Sent: 31 October 2010 21:42
To: Planning
Subject: Welwyn Hatfield Council Online Planning - Comment

Application Number: N6/2010/2055/MA

Address: 136 Cole Green Lane, WGC, AL7 JE Comment Type: Object

02. BRIDGE LEVEL PLAN : PROPOSED

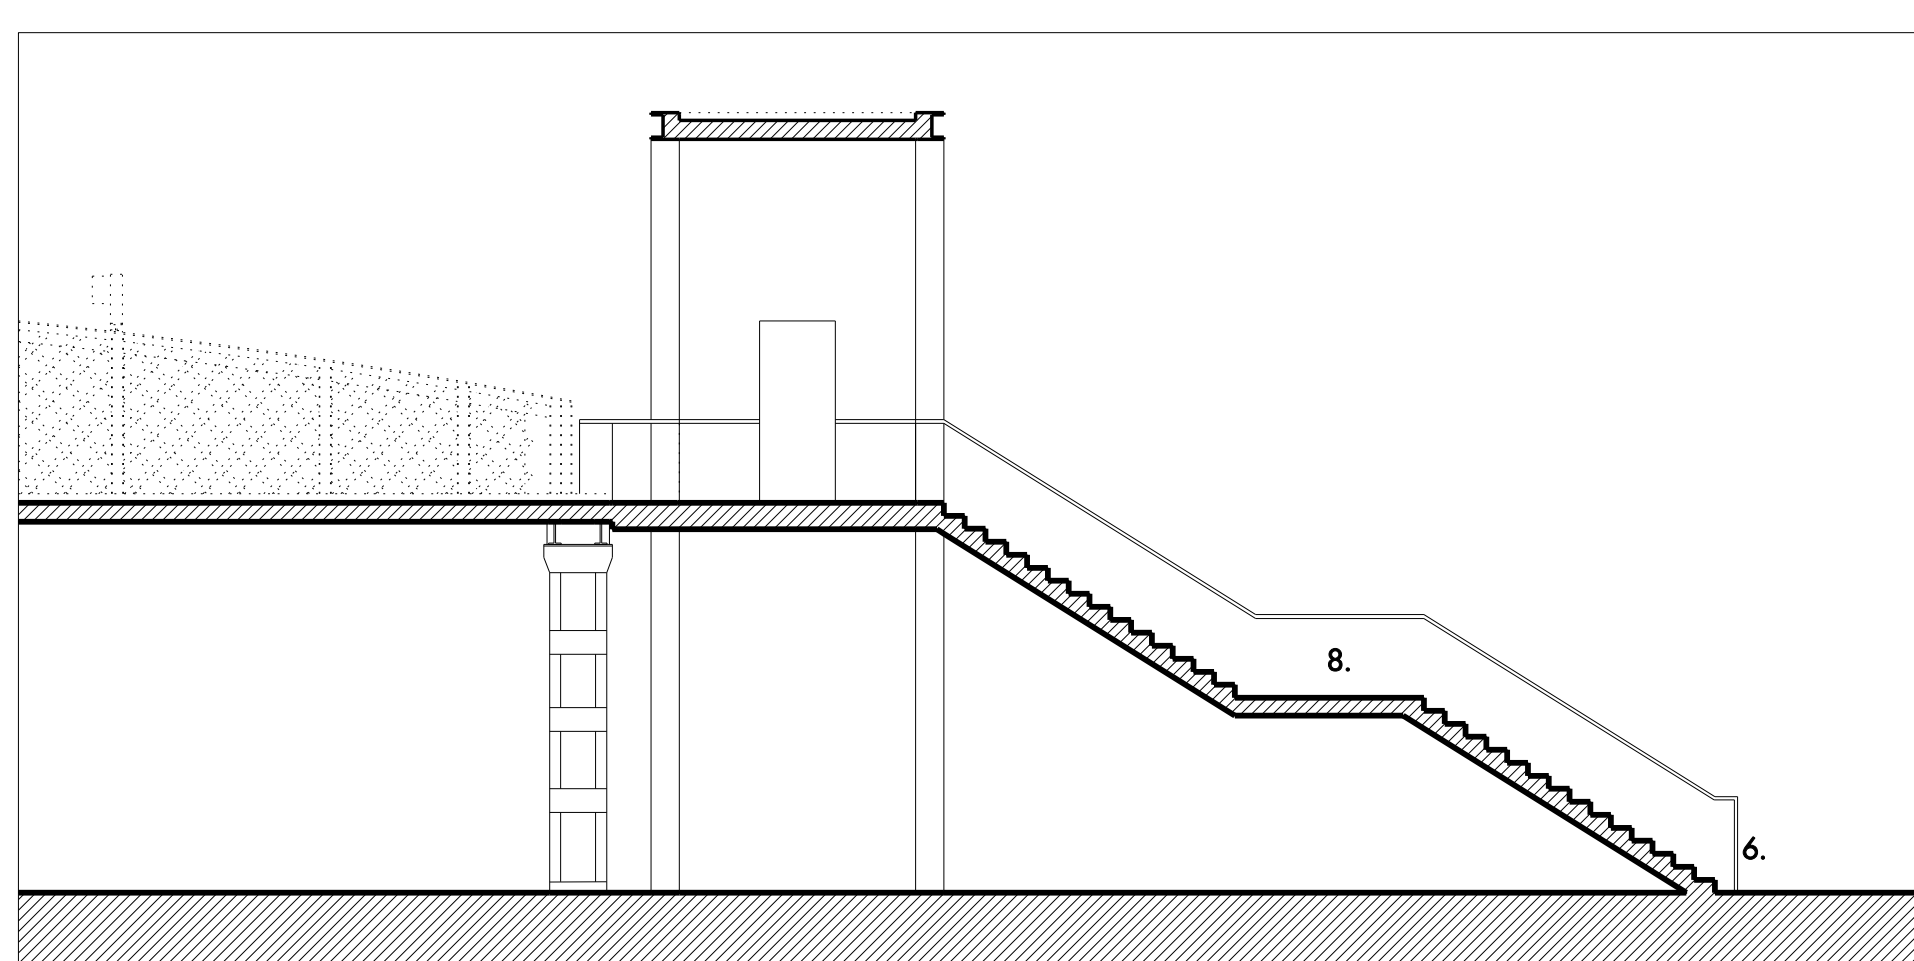
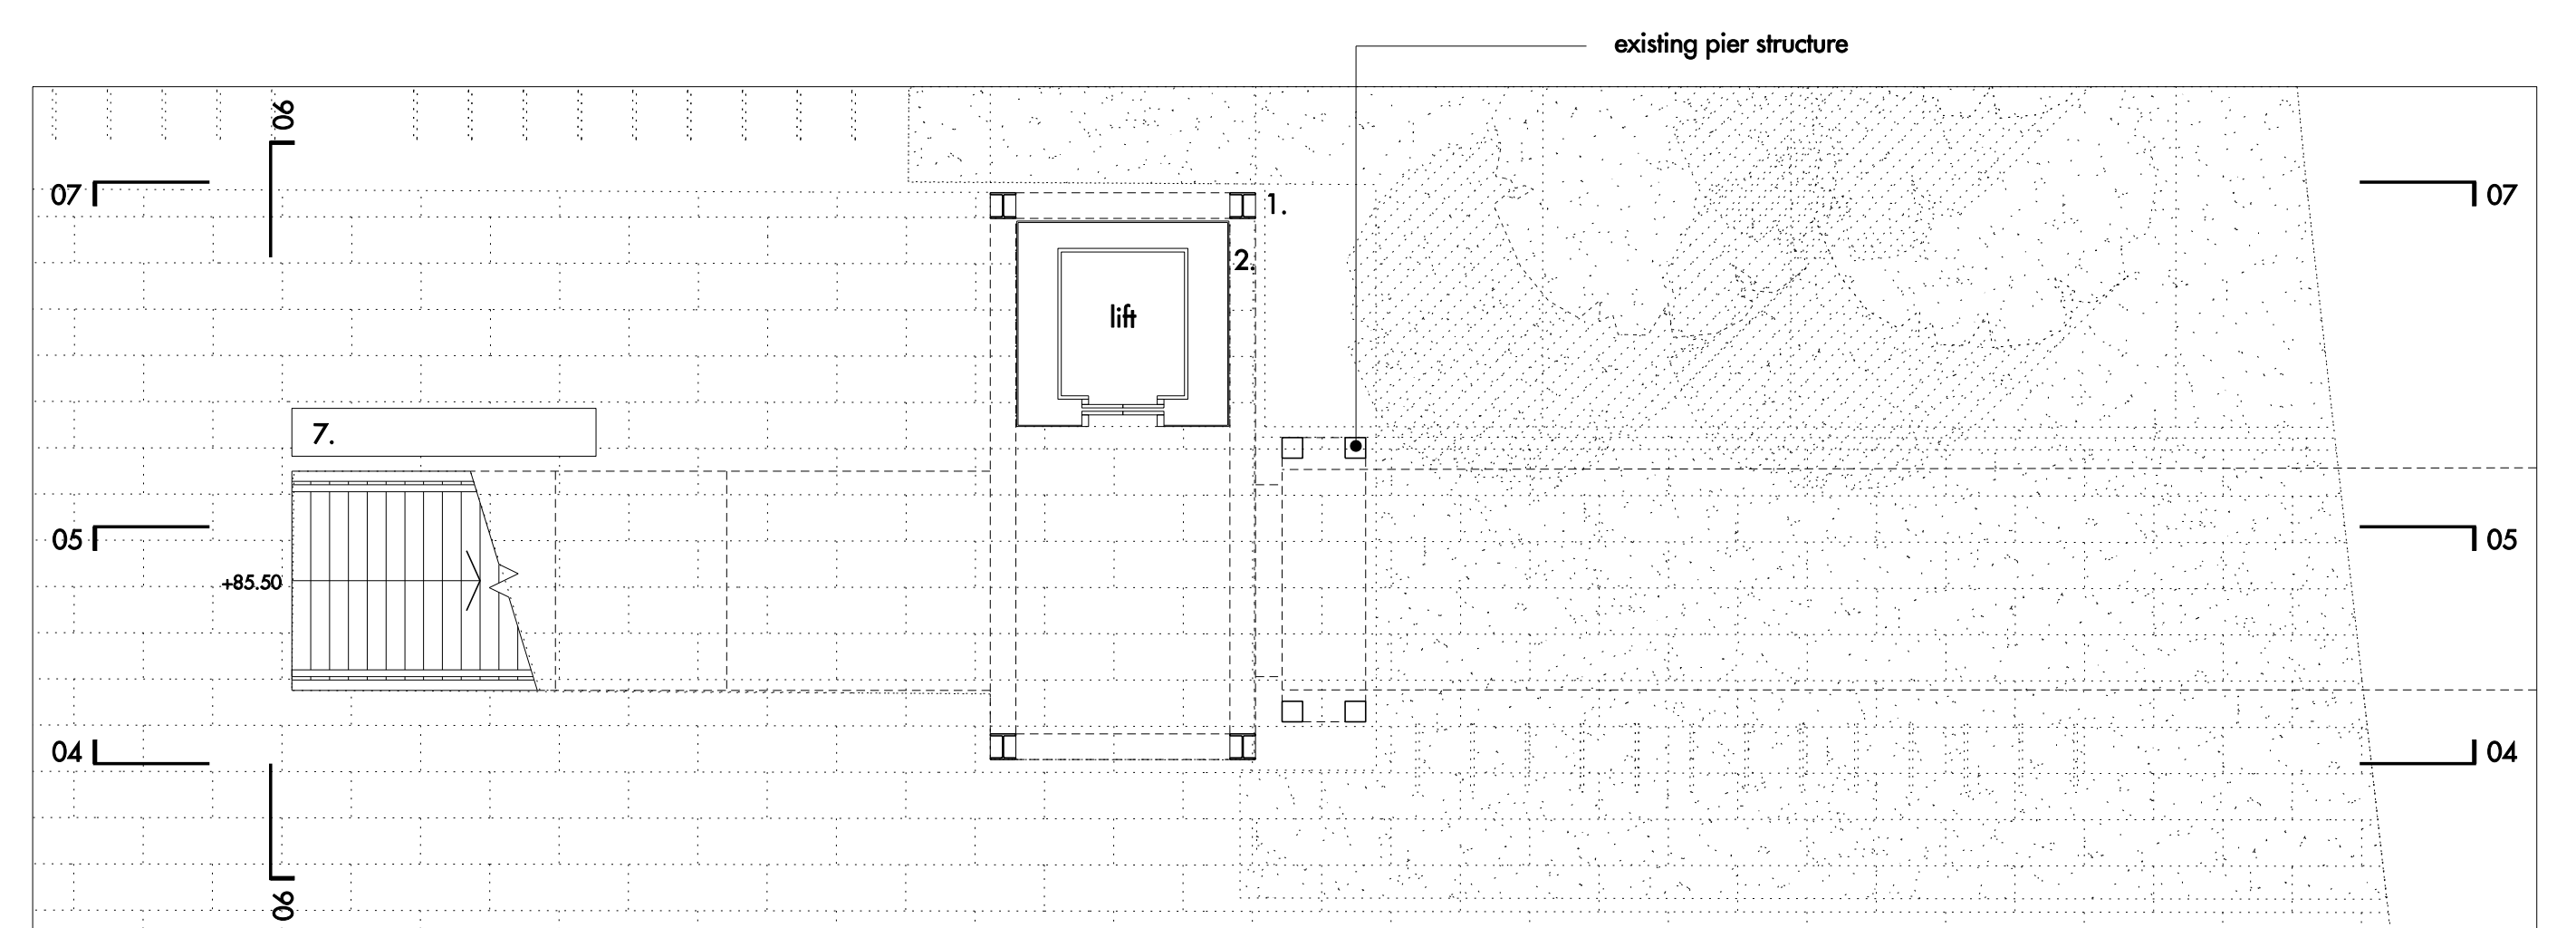
3. The footbridge plans are totally inadequate for the increased number of people expected to use it.
